REFUSAL OF PLANNING PERMISSION

APPLICATION NO. 2011/0151

Proposal Erection of 1 no. detached dwellinghouse (Resubmission)

At 32 Summer Lane, Royston, Barnsley, S71 4SE

EXISTING BLOCK PLAN:

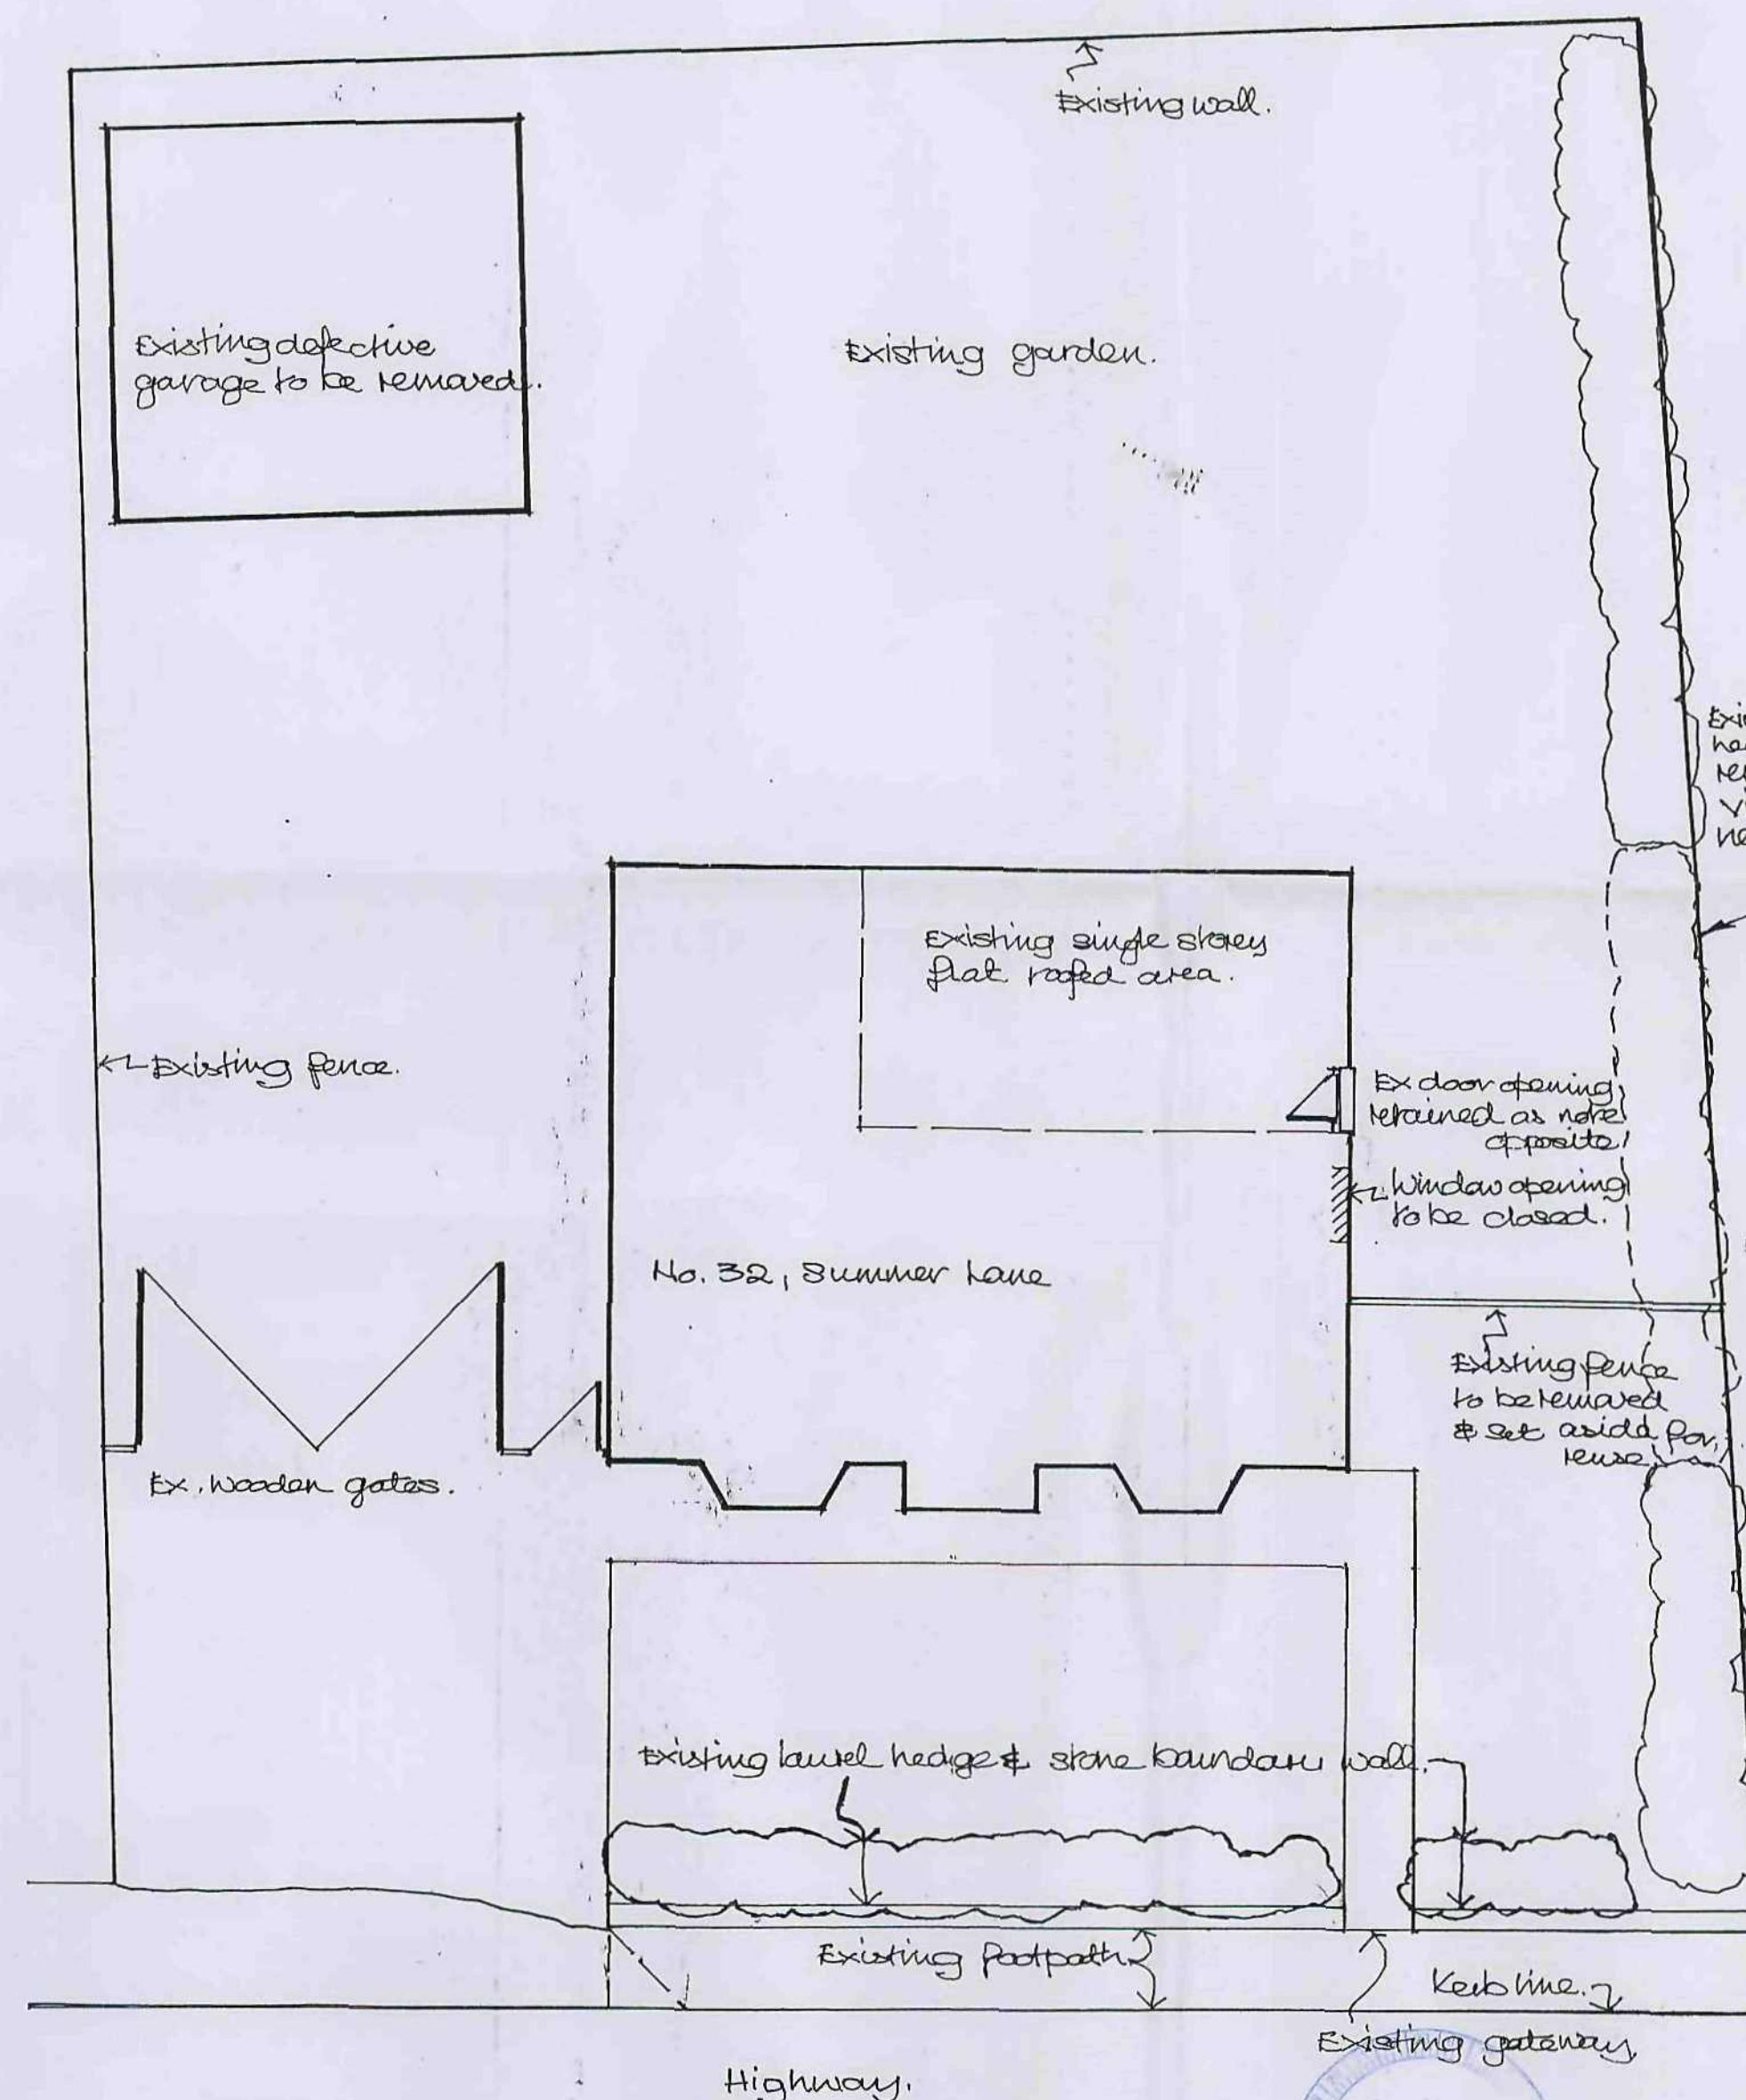
- 1 In the opinion of the Local Planning Authority the proposed dwelling would be contrary to Policy H8D of the Unitary Development Plan and the Council's Supplementary Planning Guidance Note 3 in that its position and design, in terms of the narrow plot and proximity to number 32 Summer Lane, would be architecturally inconsistent and not harmonise with the character of the adjacent properties. As a consequence of the above it would unreasonably affect the character of number 32 and would appear as an unduly intrusive feature in the street scene to the detriment of visual amenity.
